From: Amanda Scholes on behalf of Planning.Responses
Sent: 06 January 2022 09:12
To: Planning Scanning
Subject: FW: Planning consultation - CM/57/21/PL Climping Campsite Brookpit Lane Climping BN17 5QU

From: Ian Stocks [REDACTED] On Behalf Of FRS Water and Access
Sent: 06 January 2022 07:49
To: Planning.Responses [REDACTED]
Subject: Planning consultation - CM/57/21/PL Climping Campsite Brookpit Lane Climping BN17 5QU

Having viewed the details for Planning application no. CM/57/21/PL for the change of use from campsite to 2 No. holiday lets with associated building and landscaping alterations, the nearest fire hydrant the site is 420 metres away, 330 metres further than the 90 metres distance required for a commercial premises. If an alternative supply of water for firefighting is to be considered it will need to conform with the details identified in Approved Document – B (AD-B) Volume 2 2019 edition: B5 section 16. ensure it is within 90 metres of a fire hydrant. If they are not within this distance an additional fire hydrant will be required.

LOCATION PLAN

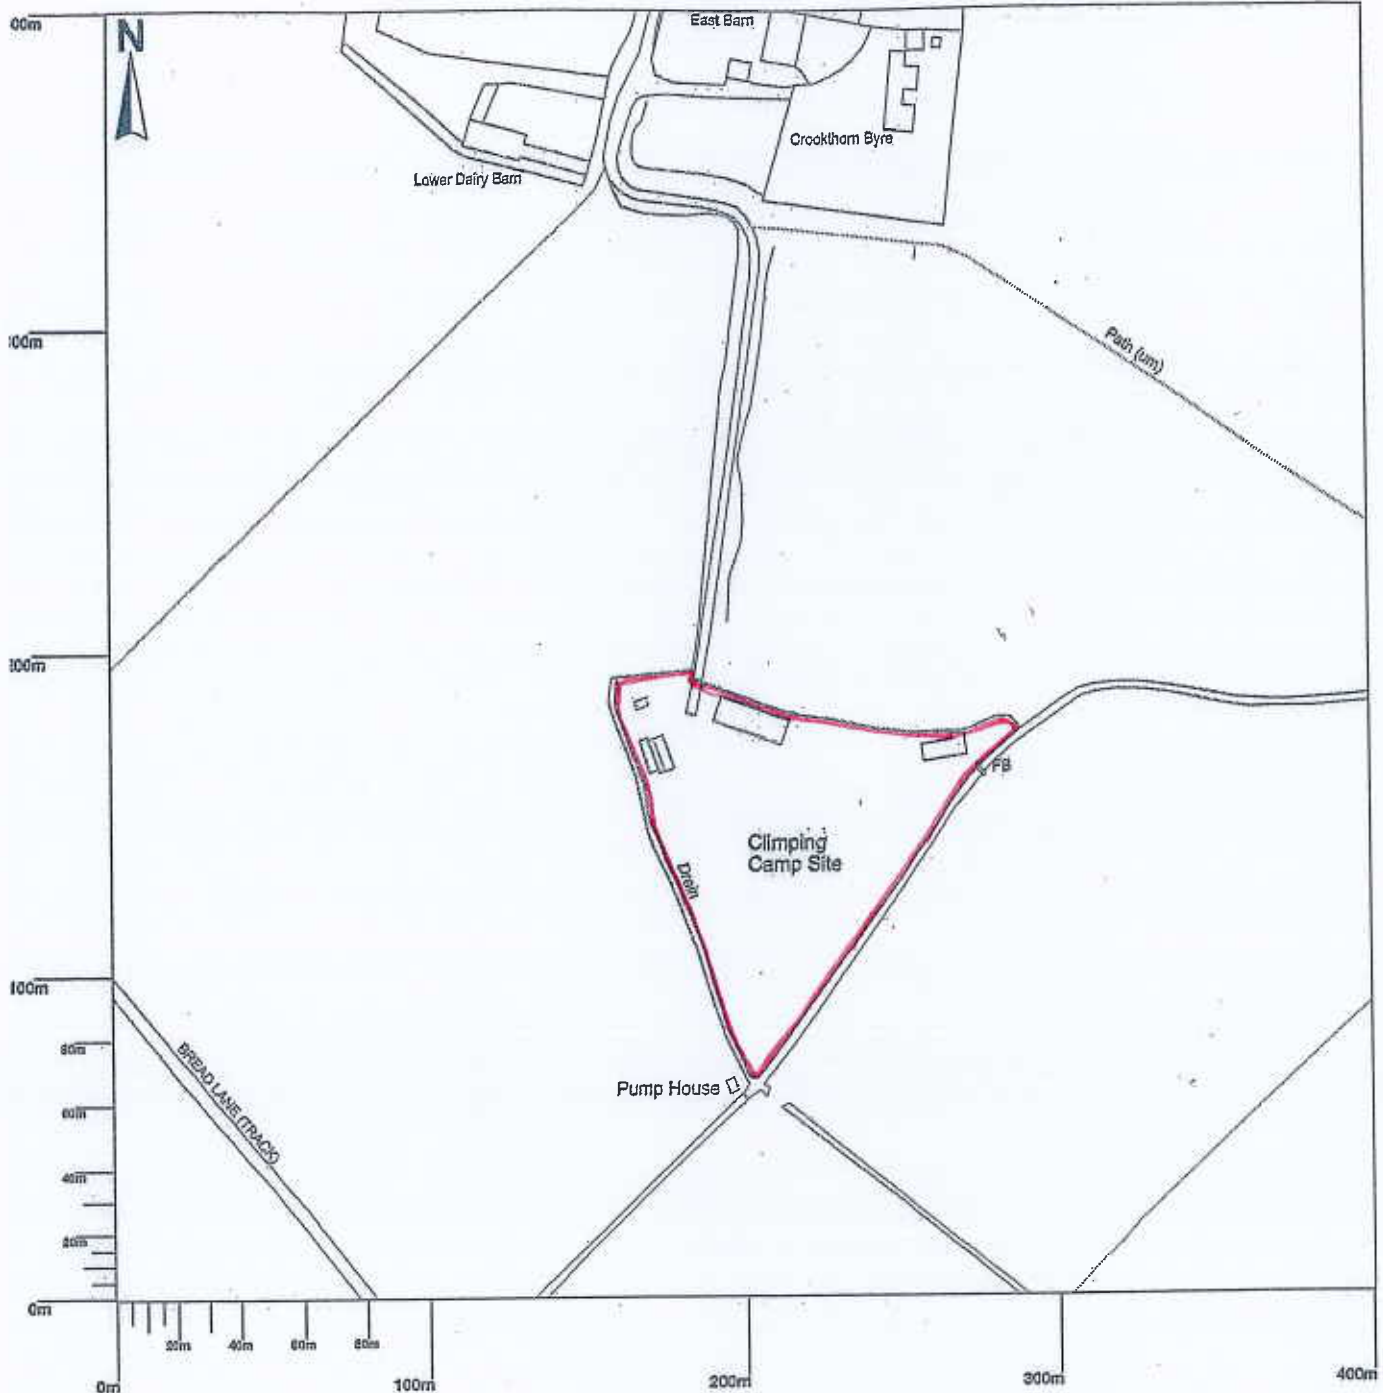
Information is also required to show there is sufficient width for a fire appliance to gain access to within 45 metres of the property or 15% of the perimeter. The minimum access width required is 3.1 metres through a gateway and 3.7 metres between kerbs or the edge of the access track and capable of supporting 12 to 18 Tonne axial weight of a fire appliance. Sections of the access route appear to be less than 3 metres wide. The access requirements are identified in AD-B Volume 2 B5 section 15 Table 15.2.

Without sufficient access width a fire appliance would not be capable of attending the 2 holiday lets in the event of any fire or emergency.
